DEPARTMENT OF PARKS AND COMMUNITY SERVICES

November 19, 2024

Subject: Flying Horse North Phase Filing No. 4 Final Plat, 2nd Submittal (SF-24-022)

**CONSTRUCTION DRAWINGS
 OVERALL SITE PLAN**

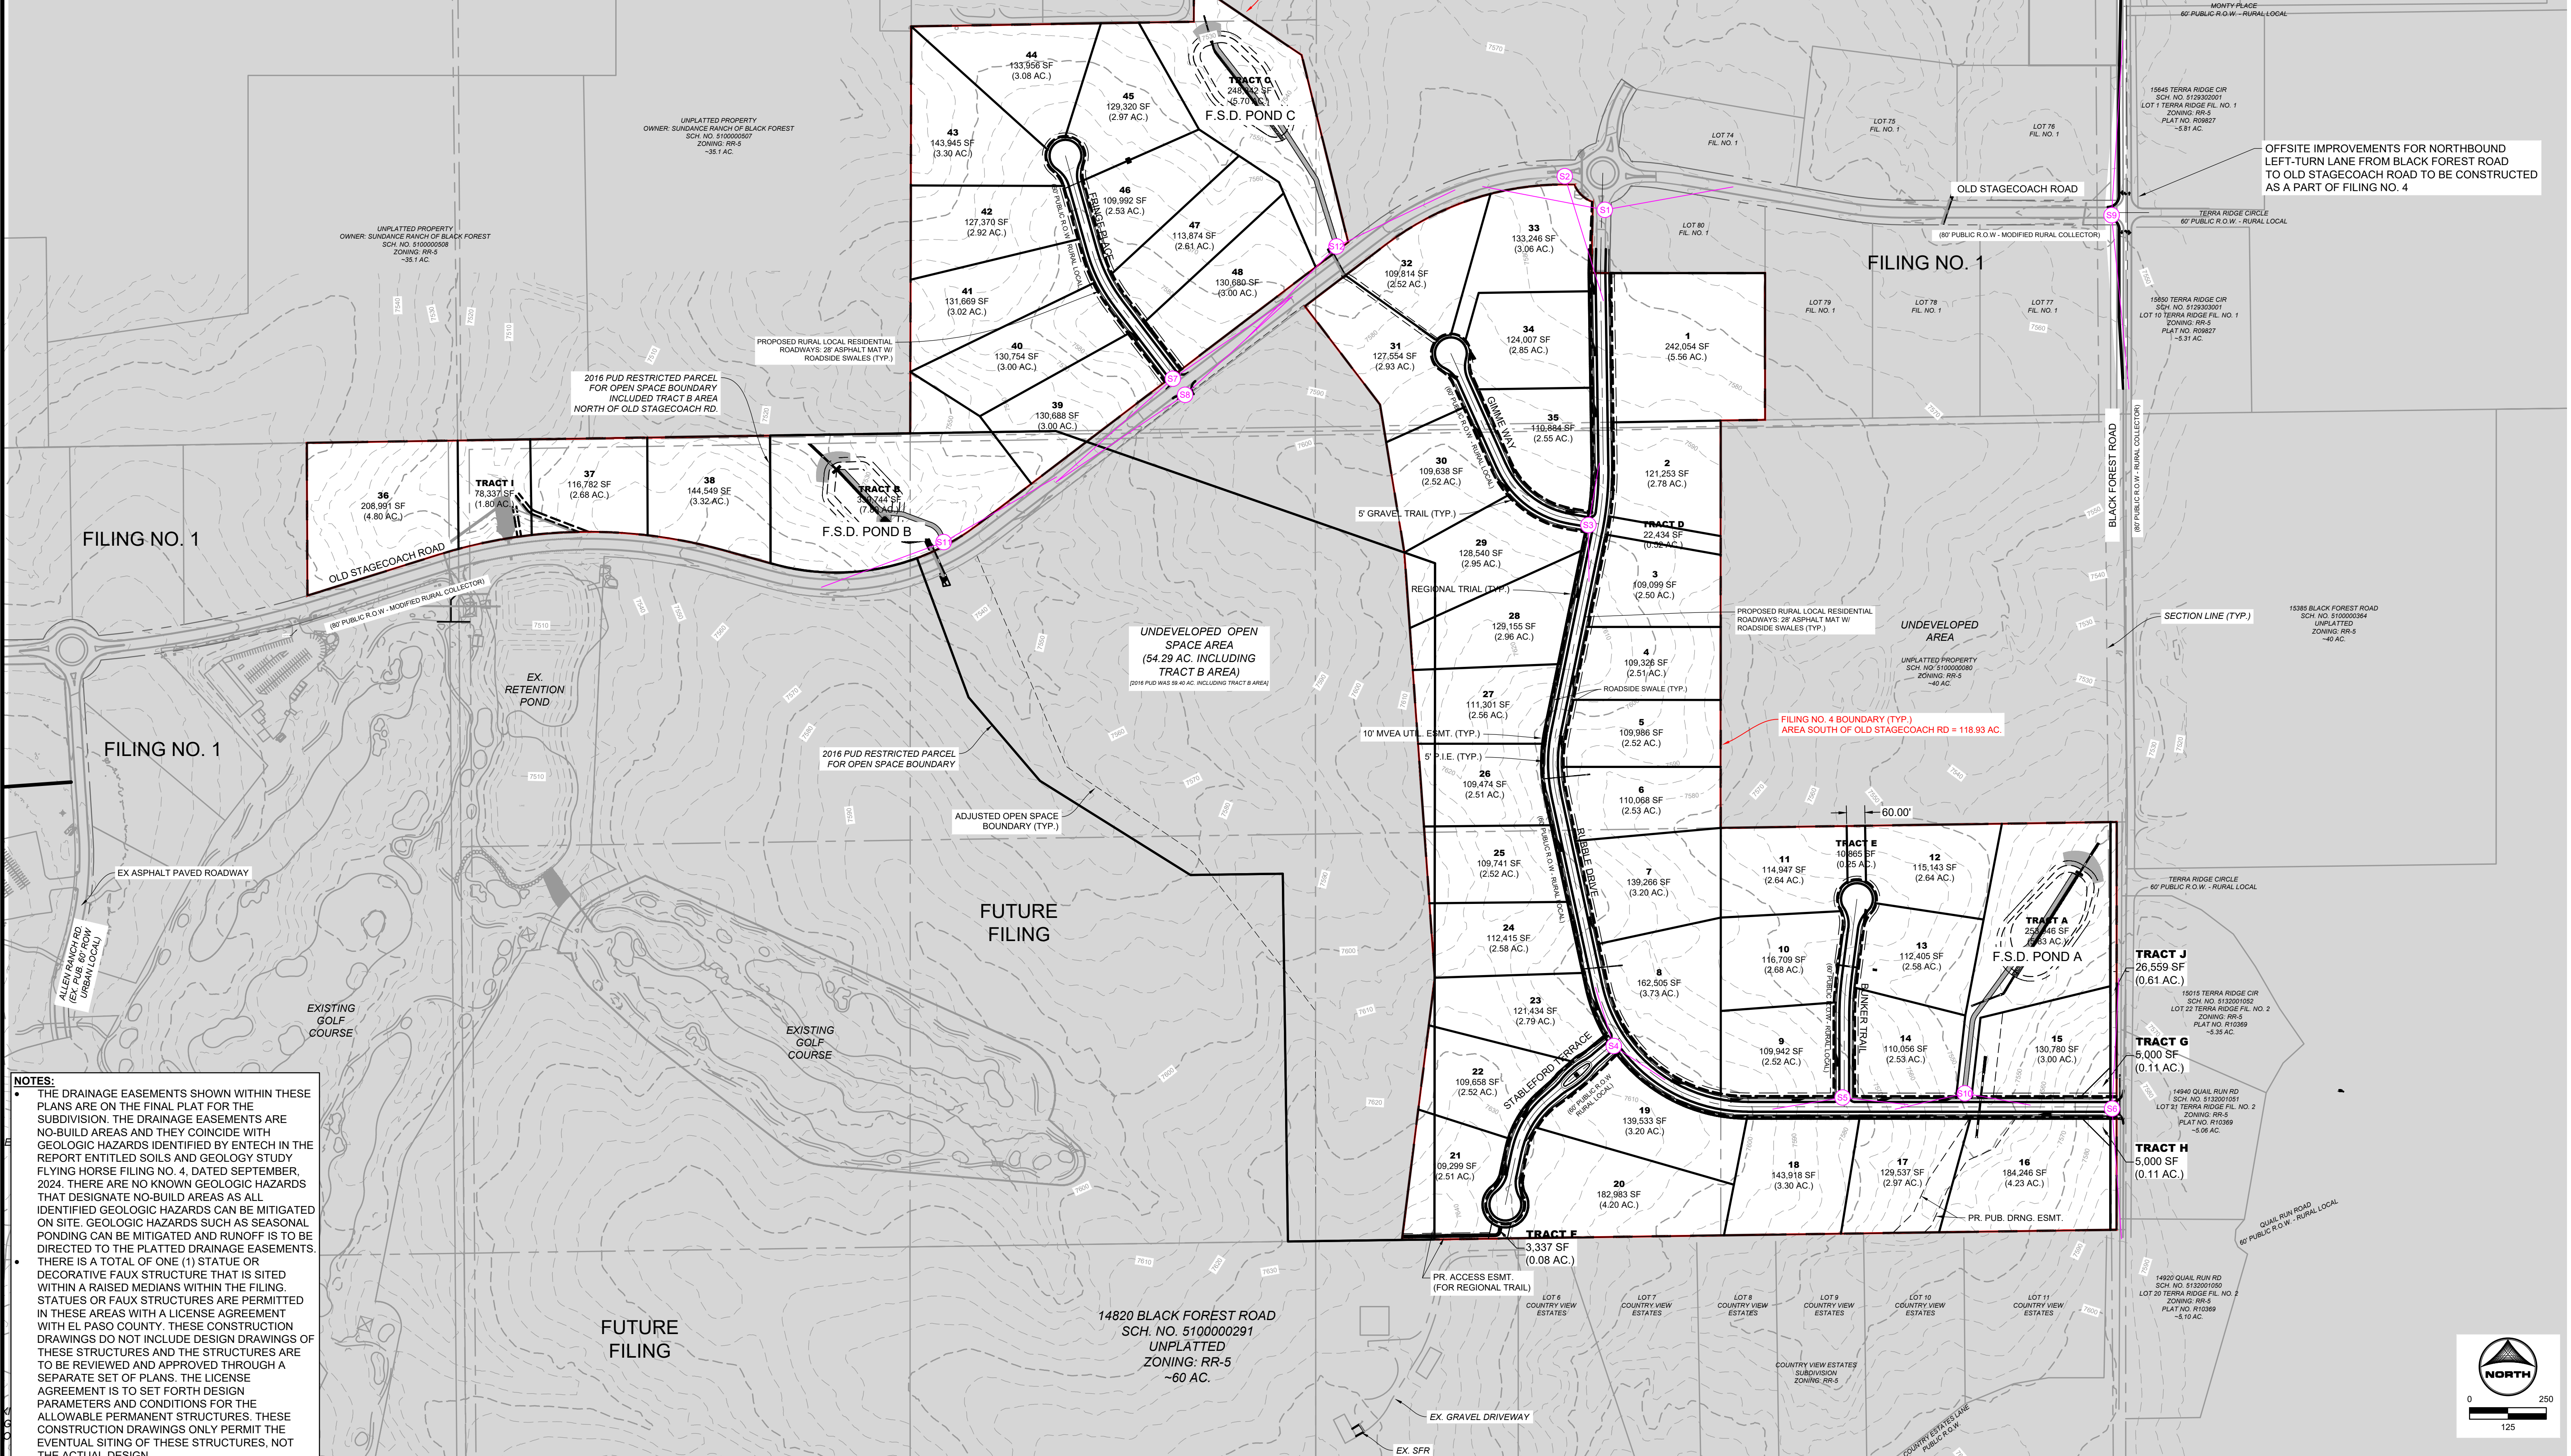
The Park Planning Division of the Parks and Community Services Department has reviewed the 2nd submittal of the Flying Horse North Filing No 4 Final Plat and is submitting the following additional comments and recommendations on behalf of El Paso County Parks. **Upon review of the submitted Final Plat and construction drawings, staff noted that the required 25' regional trail easement was not included along the south side of Old Stagecoach Road on the Final Plat, through the northernmost portions of Lots 31-33. Furthermore, the construction drawings did not show a buildable and sustainable location for the trail, which is intersected by a fairly major drainage channel between Lots 31 and 32.**

Lastly, the submitted PUD Development Plan and Preliminary Plan Amendment and Final Plat both show a “20’ Regional Trail Easement” located at the far southwestern corner of Filing No. 4. A conversation with HR Green revealed that this is actually an internal trail that will connect to the Fox Run Regional Trail and therefore should not be identified as a regional trail, nor an easement dedicated to El Paso County. However, the Trails Exhibit does show the Fox Run Regional Trail running east-west through the northern portion of Filing No. 4, along Old Stagecoach Road. As such, staff requires a 25’ public trail easement to be located on the southern side of Old Stagecoach Road, through Lots 31-33, and dedicated to El Paso County on this Final Plat.

The Park Advisory Board recommends that the Planning Commission and the Board of County Commissioners include the following conditions when considering and/or approving the Flying Horse North Filing No. 4 Final Plat: (1) designate and provide to El Paso County 25-foot wide public regional trail easement along the south side of Old Stagecoach Road through Filing No. 4 that allows for public access, as well as construction and maintenance by El Paso County of the Fox Run Primary Regional Trail, and the easement be shown, noted, and dedicated to the County via this Final Plat; and (2) fees in lieu of land dedication for regional park purposes in the amount of \$24,240 will be required at time of the recording of this Final Plat.
